DRB Application No.: 07DRB-00656 (SPS)
Project Name: RENAISSANCE CENTER
Agent: Tierra West LLC

2. Project # 1004368
07DRB-00656 Major-SiteDev Plan BldPermit

TIERRA WEST LLC agent(s) for UNION PENSION TRANSACTION TRUST 93-2, request(s) the above action(s) for all or any portion of Tract(s) 4A2, **RENAISSANCE CENTER**, zoned SU-1, IP USES, located on RENAISSANCE BLVD NE between ALEXANDER NE and CULTURE DR NE containing approximately 1 acre(s). (F-16)

ENGINEER'S SEAL	STERLING DEVELOPMENT RENAISSANCE CENTER	DRAWN BY DY
	SITE PLAN FOR BUILDING PERMIT	DATE 4-18-07
		2713-SPB
		SHEET # C1
RONALD R. BOHANNAN P.E. #7868	TIERRA WEST, LLC 5571 MIDWAY PARK PLACE NE ALBUQUERQUE, NM 87109 (505)858-3100	JOB # 27013

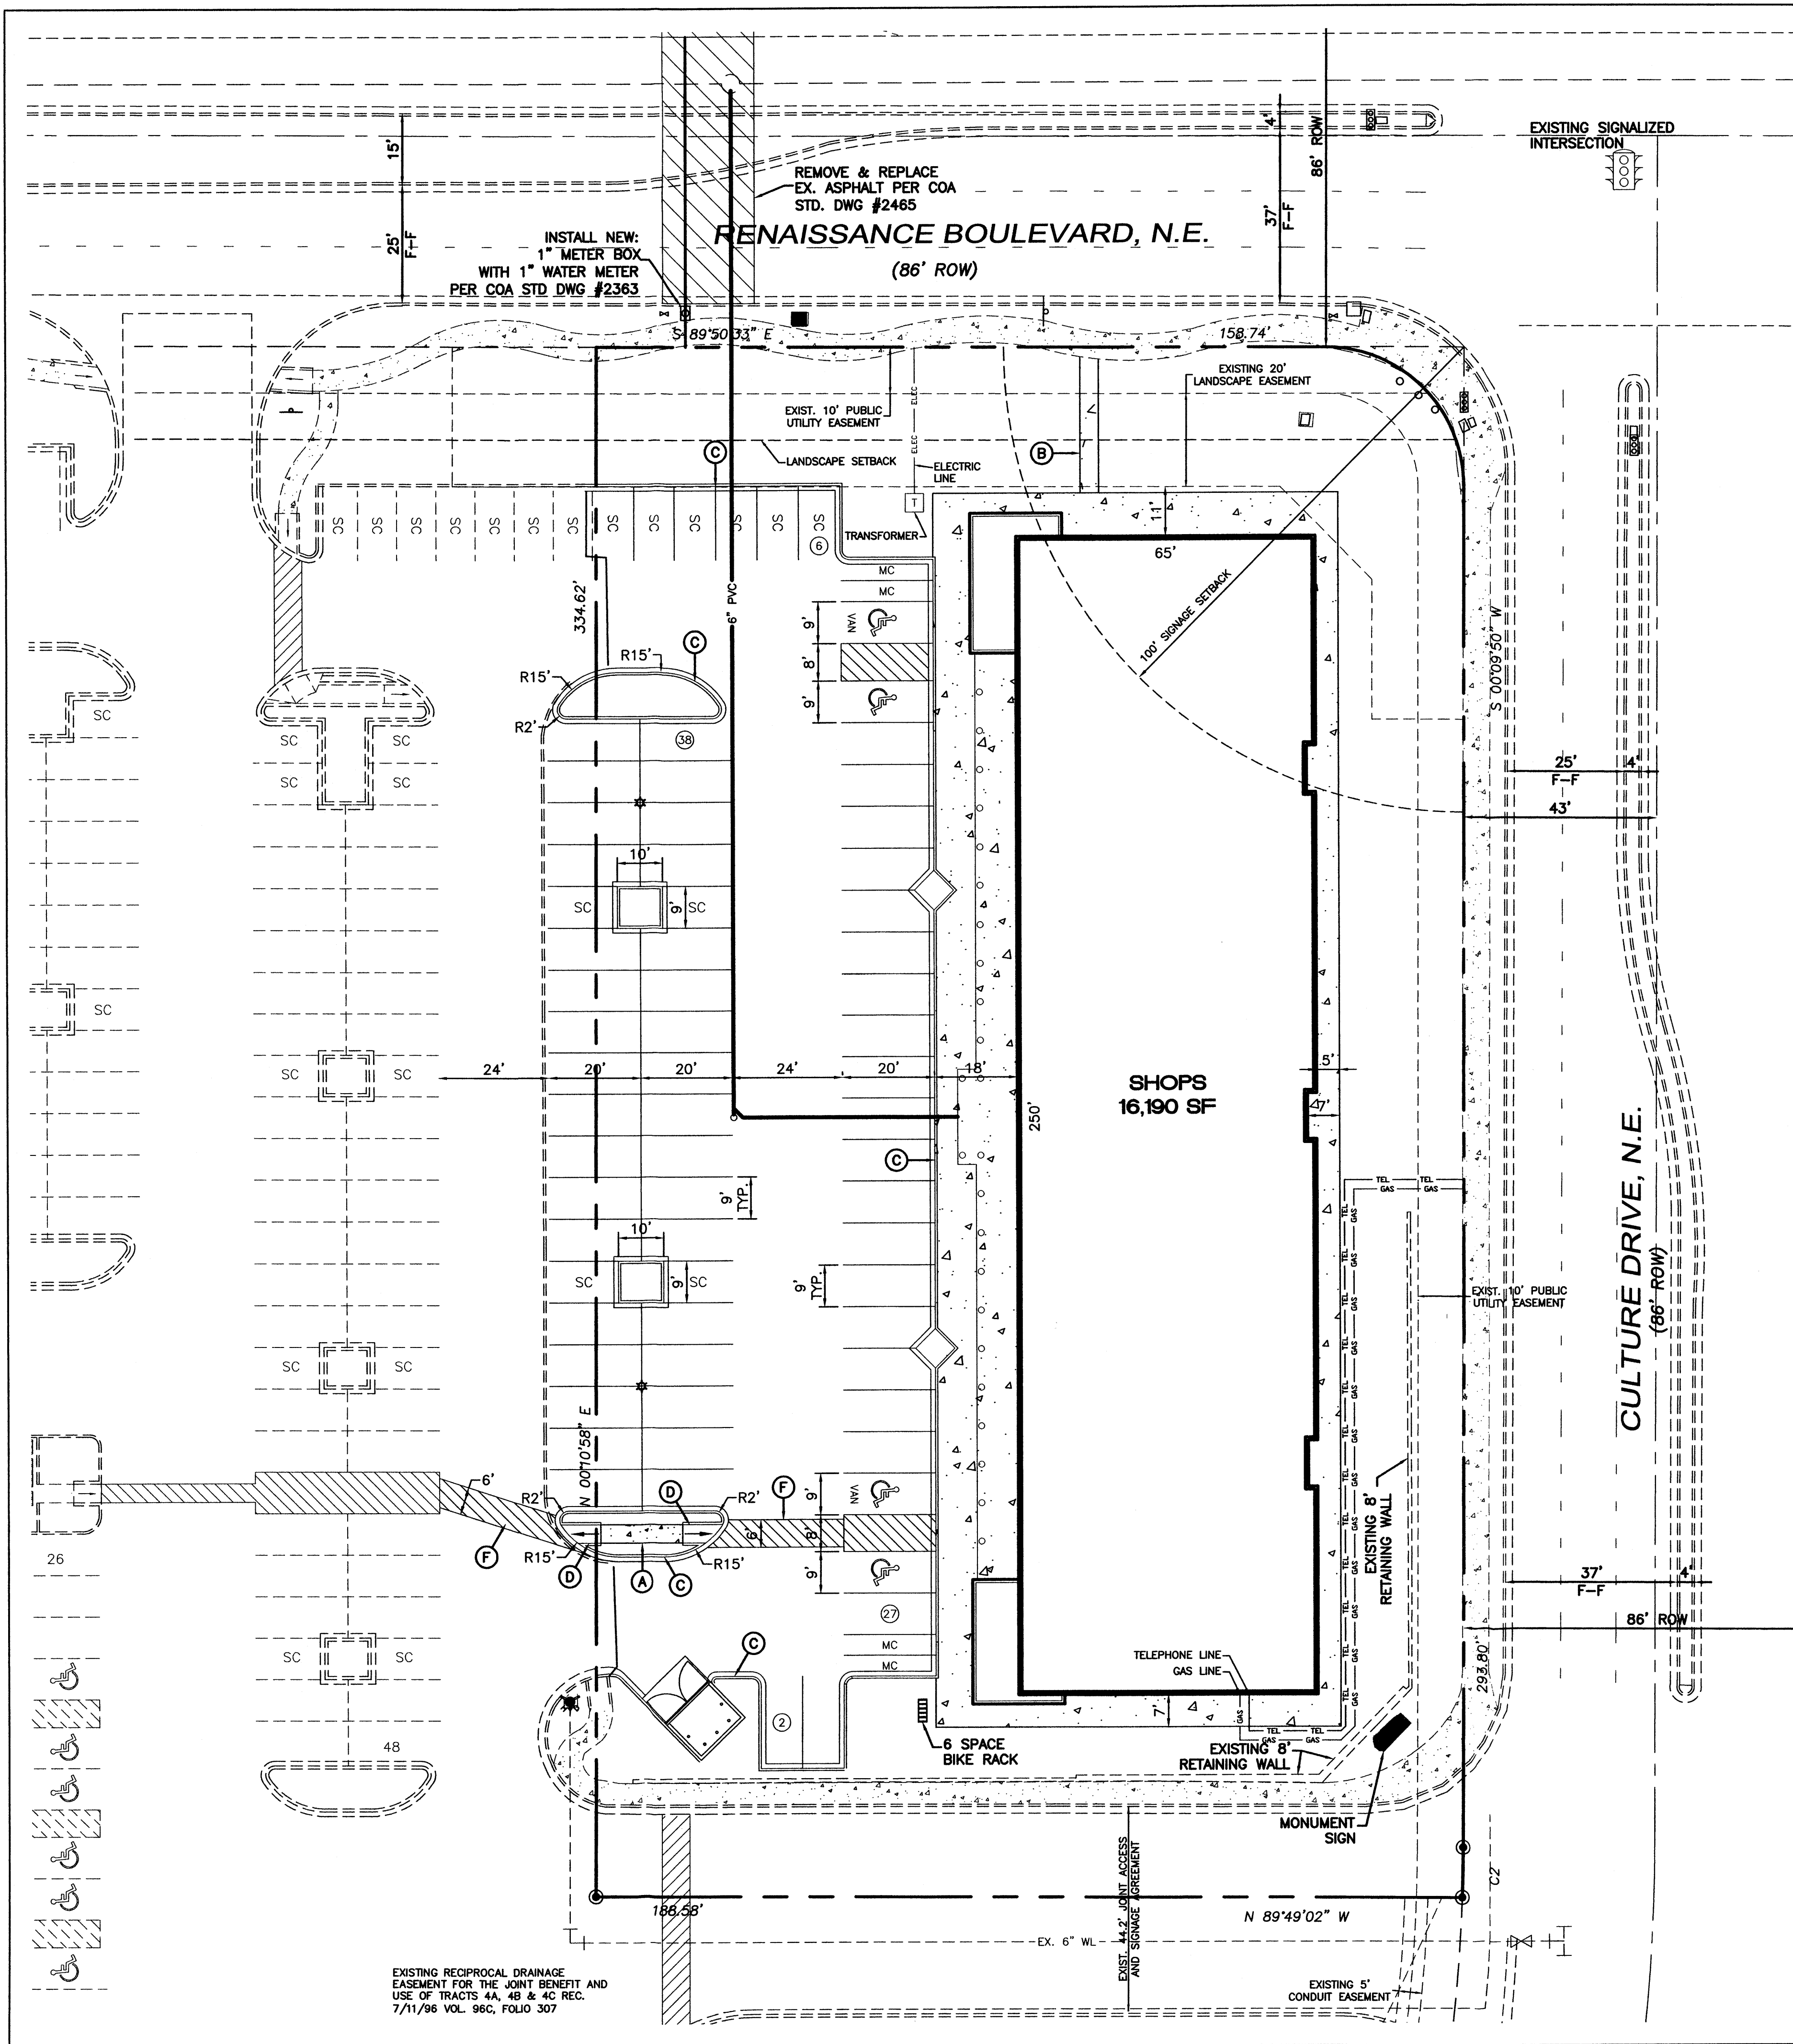
A copy of the plat is needed that shows cross access, cross parking and easements for the meandering sidewalk. Are the sidewalks within the public right-of-way existing? Are the ADA ramps in place? The motorcycle stalls need to be shortened. Has the tract paid its TIS offsite mitigation fees?

- Remove the EPC paragraph and the word "Signoff" from the signature block.
- Under "Notes", remove numbers 2 and 3.
- The location of the monument sign on the site plan sheet was not found even though it was assigned "E".
- On the Landscape Plan, the 2 references to Santa Fe Brown gravel should include "3" minimum depth".
- Under "Landscape Calculations", is the Offsite Area the square footage of the lot located in the access road?

STERLING DEVELOPMENT RENAISSANCE CENTER	DRAWN BY AD
	LANDSCAPE PLAN	DATE -04-07
	TERRA WEST, LLC 5571 MIDWAY PARK PLACE NE ALBUQUERQUE, NM 87109 (505) 858-3100	2713-SPB
		SHEET # L1

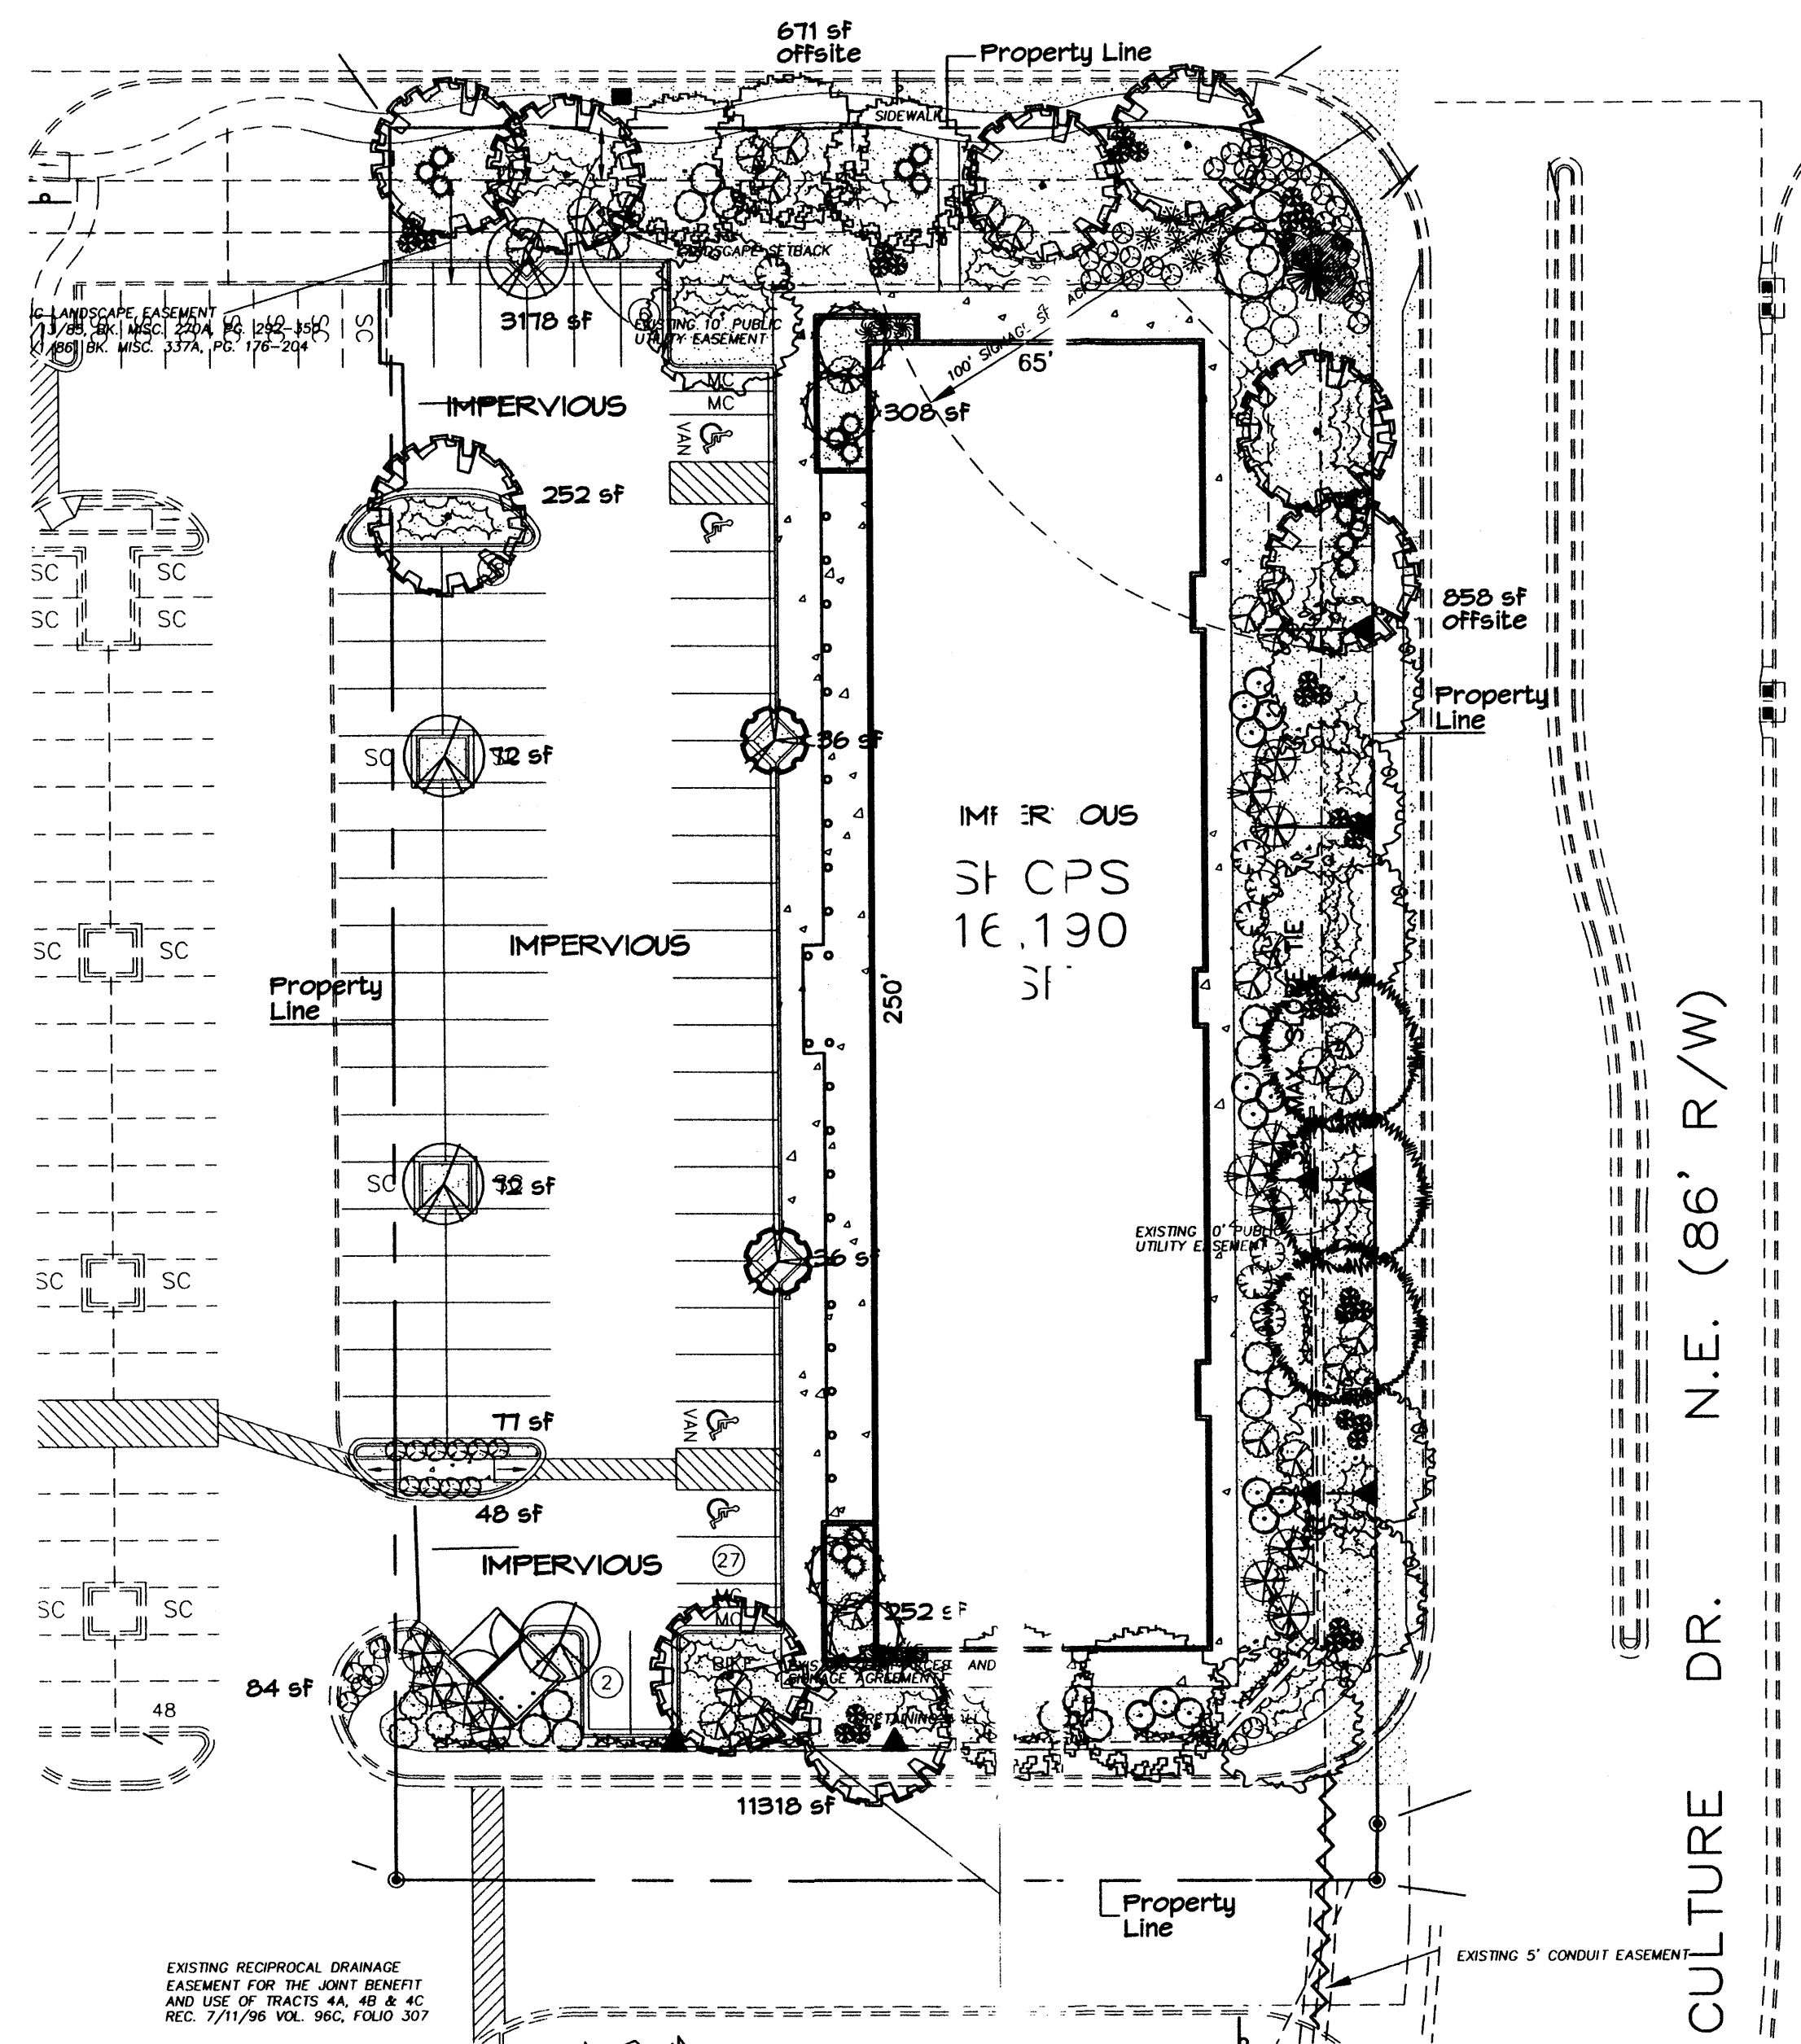
The Renaissance Master Plan (RMP) requires 1 tree per 20 lineal feet of frontage. Culture requires: 293.8 ft divided by 20 = 14 trees. The Landscape Plan has 11 trees. Renaissance Blvd.requires 7 trees. 158.74 divided by 20 = 7 trees. The Landscape Plan has 6 trees.

The RMP requires a minimum 4 varieties of shade trees. The Landscape Plan shows 2 varieties. The minimum size requirement for shrubs and vines is 5 gallon.
